**COMMUNITY SERVICES DEPARTMENT**

April 1, 2021

**Subject: Homestead North at Sterling Ranch Phase I Preliminary Plan, Review #2 (SP-20-008)**

**PRELIMINARY
SITE PLAN**

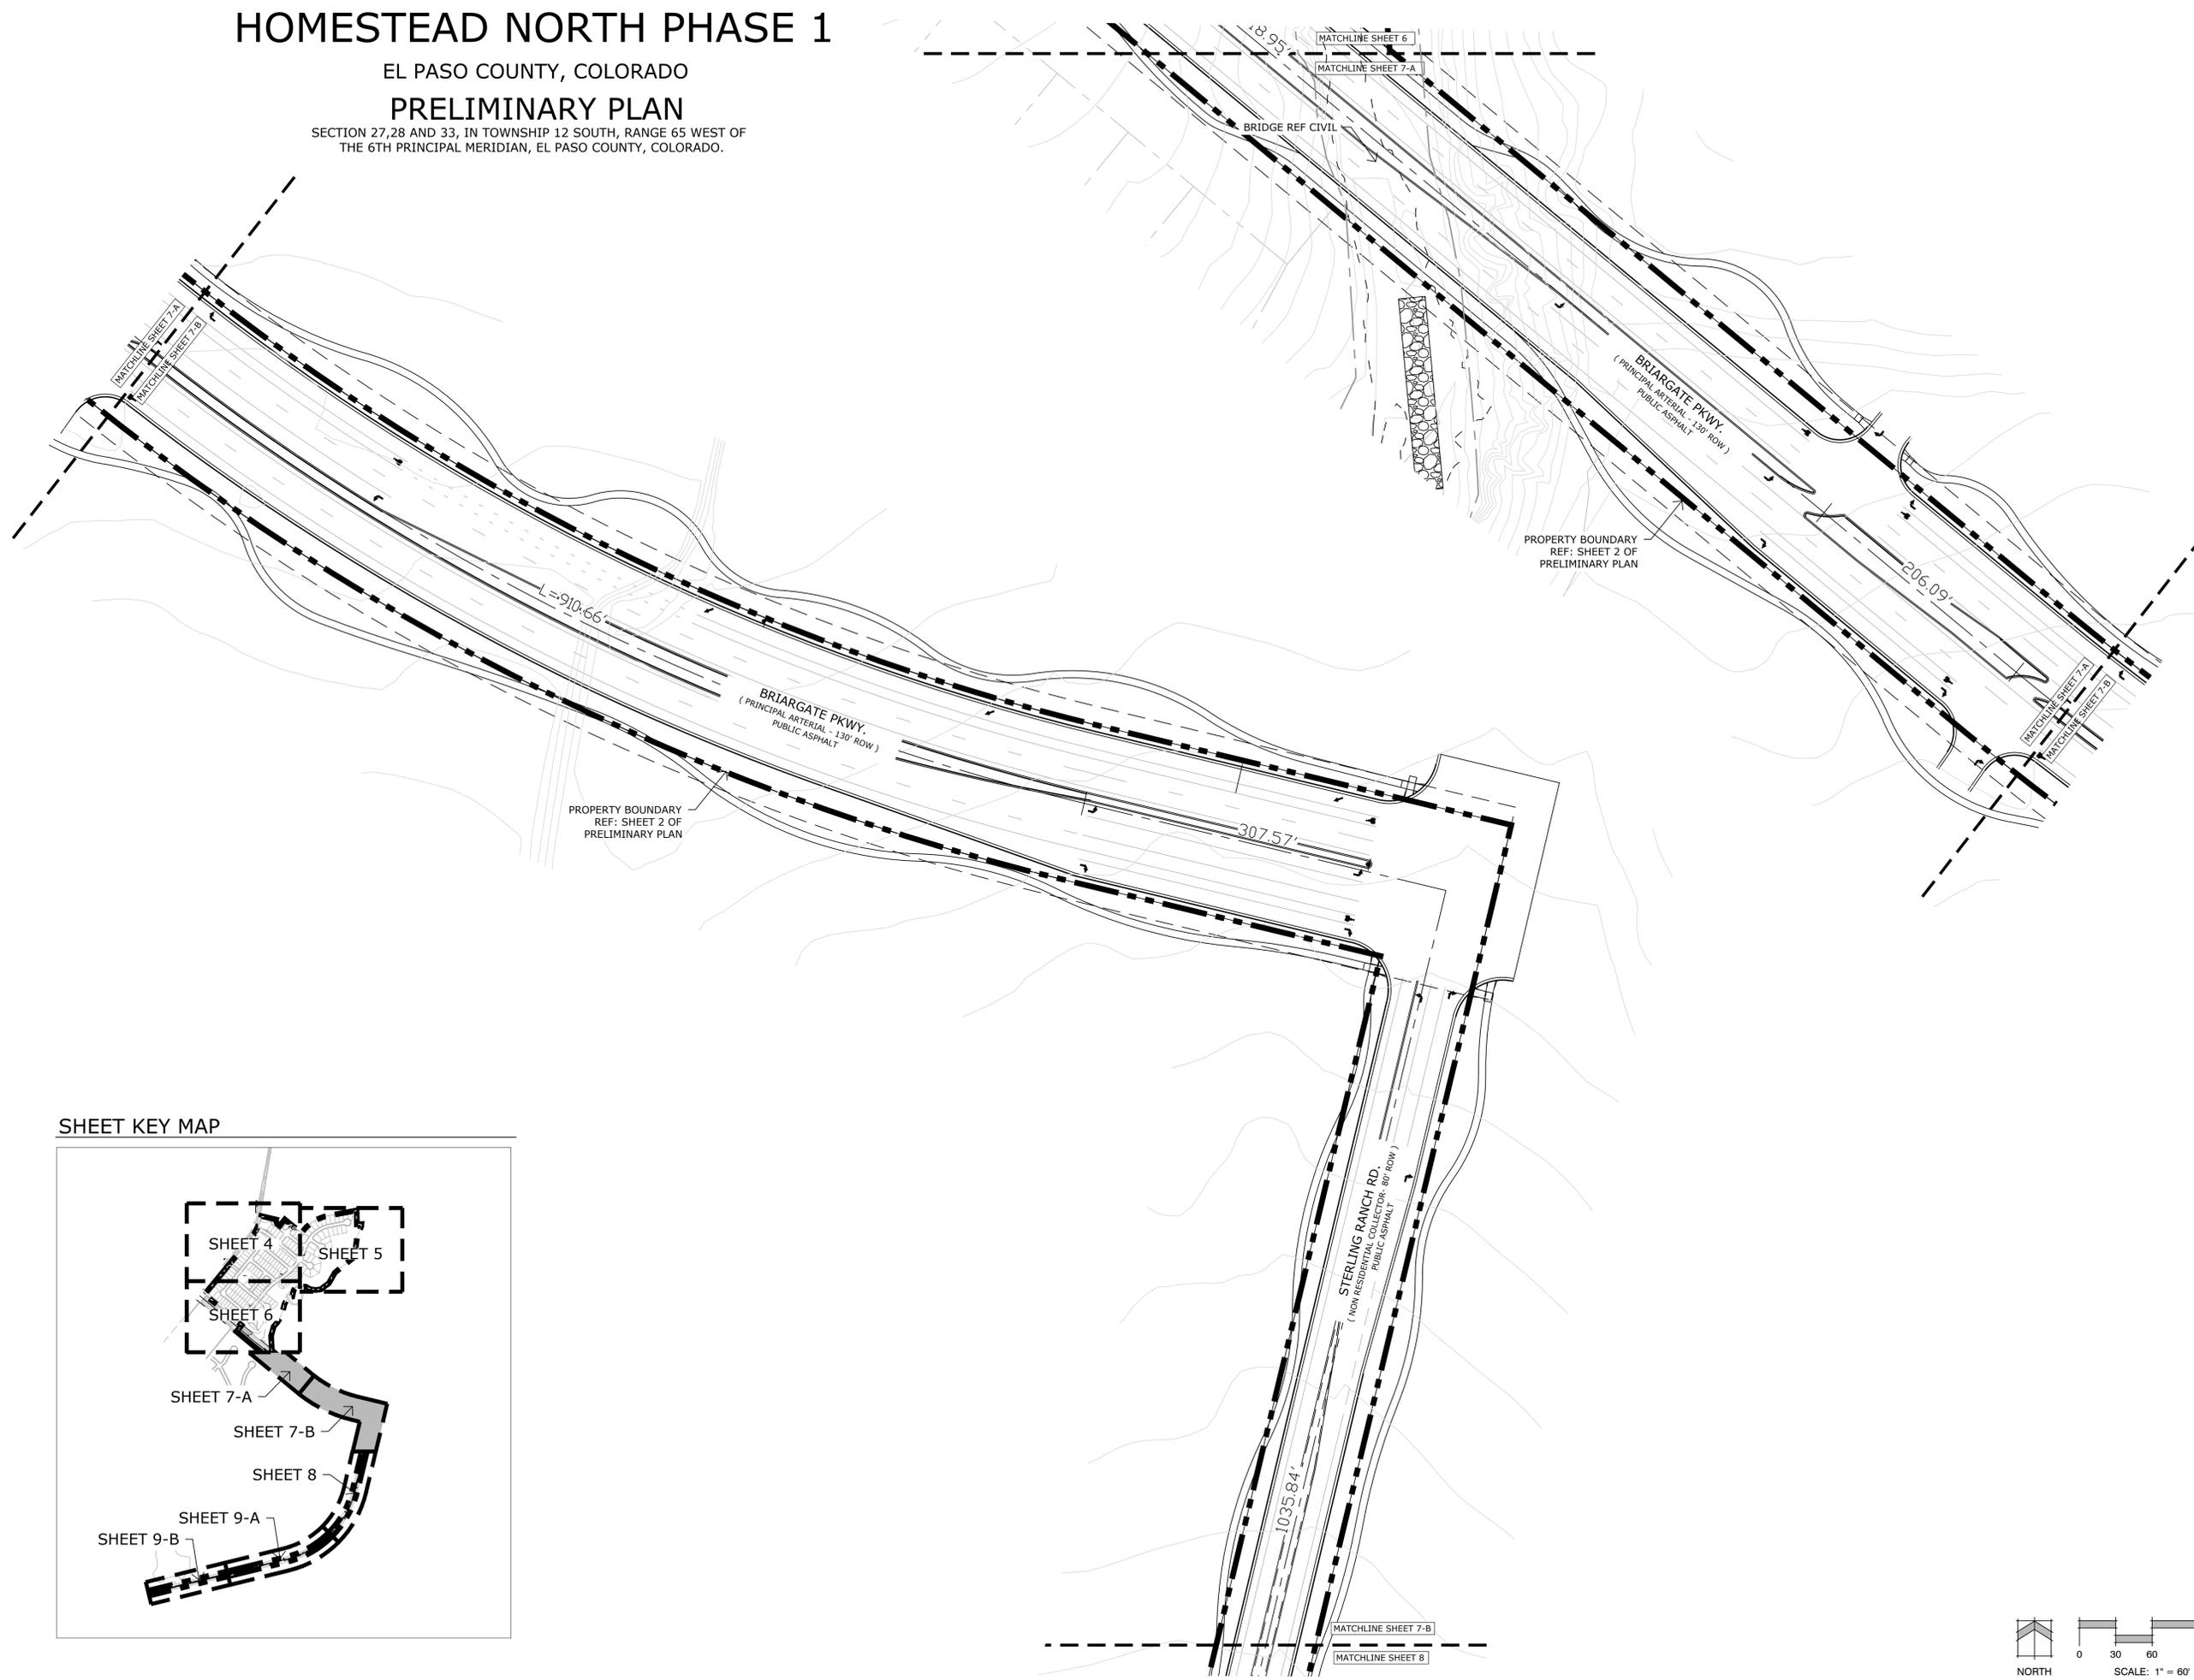
The Park Operations Division of the Community Services Department has reviewed the Homestead North at Sterling Ranch Phase I Preliminary Plan, Review #2, development applications and has the following additional comments of behalf of El Paso County Parks. **Staff questions the removal of the Sand Creek Regional Trail alignment and labeling from the Preliminary Plan, particularly on the cover page and Site Plans. The included utility and grading plans do show what appears to be the Sand Creek Regional Trail, but there are no labels indicating it as so. As noted in the following comments and recommendations, as endorsed by the Park Advisory Board on January 13, 2021, EPC Parks is requesting a 25' trail easement for the construction and maintenance of the Sand Creek Regional Trail. Staff also requests clarification as to the number of neighborhood parks proposed for Homestead North. The current Letter of Intent mentions one 0.87-acre park located in Tract B, but also indicates a park in Tract F. The location of the Tract F park is not indicated in the Preliminary Plan. Furthermore, staff acknowledges the increase in Preliminary Plan acreage from 60.6 acres to 77.7 acres due to the inclusion of the eastern and southern extensions of Briargate Parkway and Sterling Ranch Road, respectively.**

The proposed Sand Creek Regional Trail is depicted in the Preliminary Plan, and labeled as "10' County Gravel Trail," although when constructed, the trail will follow EPC Parks Tier I Trail standards with an 8' wide crusher fine trail surface with 2' natural shoulders. The Preliminary Plan also shows concrete sidewalks/trails located adjacent Vollmer Road and the future Briargate Parkway extension. These non-County trails will allow for direct off-street connectivity to the Sand Creek Regional Trail for the residents and visitors of Sterling Ranch.

Due to the location of the Sand Creek Primary Regional Trail within the Homestead North at Sterling Ranch Phase I development, El Paso County Parks staff recommends that the applicant designate, provide, and dedicate to El Paso County a 25-foot trail easement that allows for the construction, maintenance, and public access of the regional trail. Furthermore, staff recommends fees in lieu of land dedication for regional and urban park purposes.

The Park Advisory Board recommends that the Planning Commission and the Board of County Commissioners include the following conditions when considering and/or approving the Homestead North at Sterling Ranch Phase I Preliminary Plan: (1) designate and provide to El Paso County a 25-foot trail easement through Homestead North at Sterling Ranch, within Tract F, that allows for construction, maintenance, and public access of the Sand Creek Primary Regional Trail, and dedicate the easement to El Paso County prior to the recording of the forthcoming final plat(s); 2) include descriptions, drawings, and locations of the two neighborhood parks in the Letter of Intent and Preliminary Plans, respectively; 3) fees in lieu of land dedication for regional park purposes in the amount of \$68,649 and urban park fees in the amount of \$43,365 will be required upon recording of the forthcoming final plat(s). A Park Lands Agreement may be an acceptable alternative to urban park fees, provided the agreement is approved by the County and executed prior to recording the forthcoming final plat(s)."
